# CITY OF ALBUQUERQUE

November 29, 2011

**Re: Los Candelarias Town homes, Grading and Drainage Plan  
Engineer's Stamp date 9-29-11 (G14/D073)**

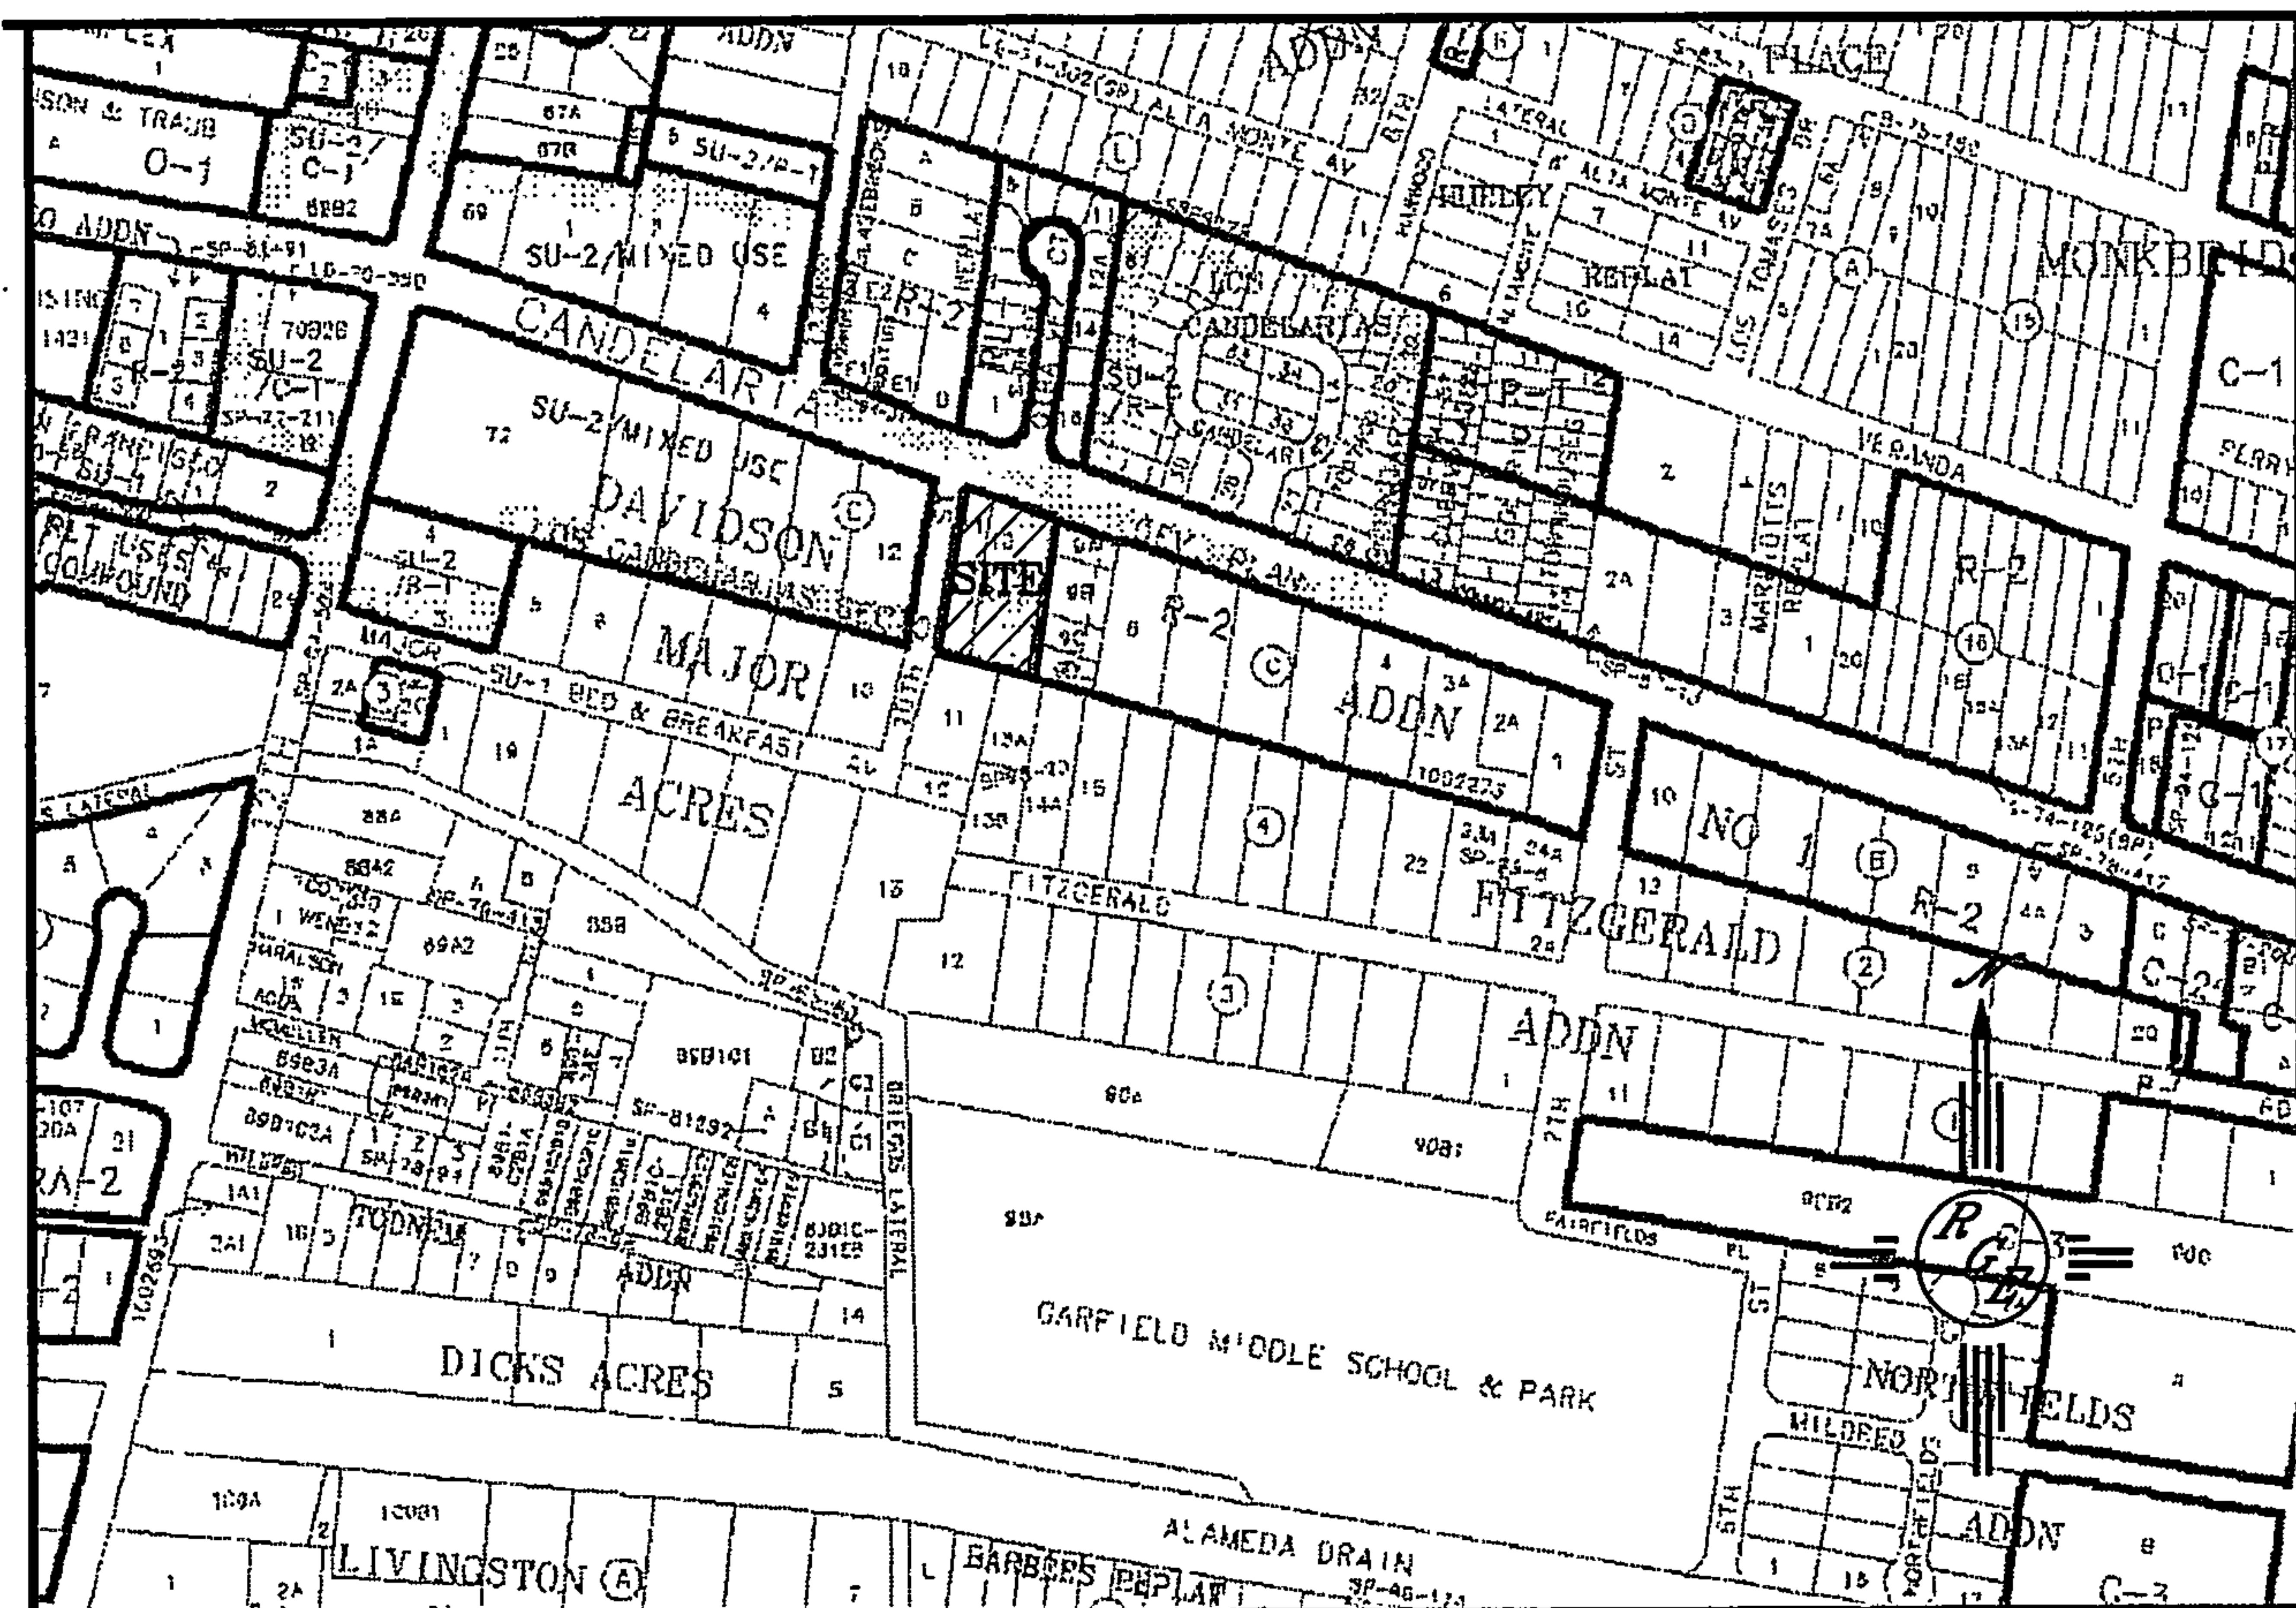
- Hydrology has been waiting for Final Plat approval, wherein the Planning member of the DRB will approve the wall along the southern boundary. If the wall is to be moved/removed an updated Grading Plan will be required.
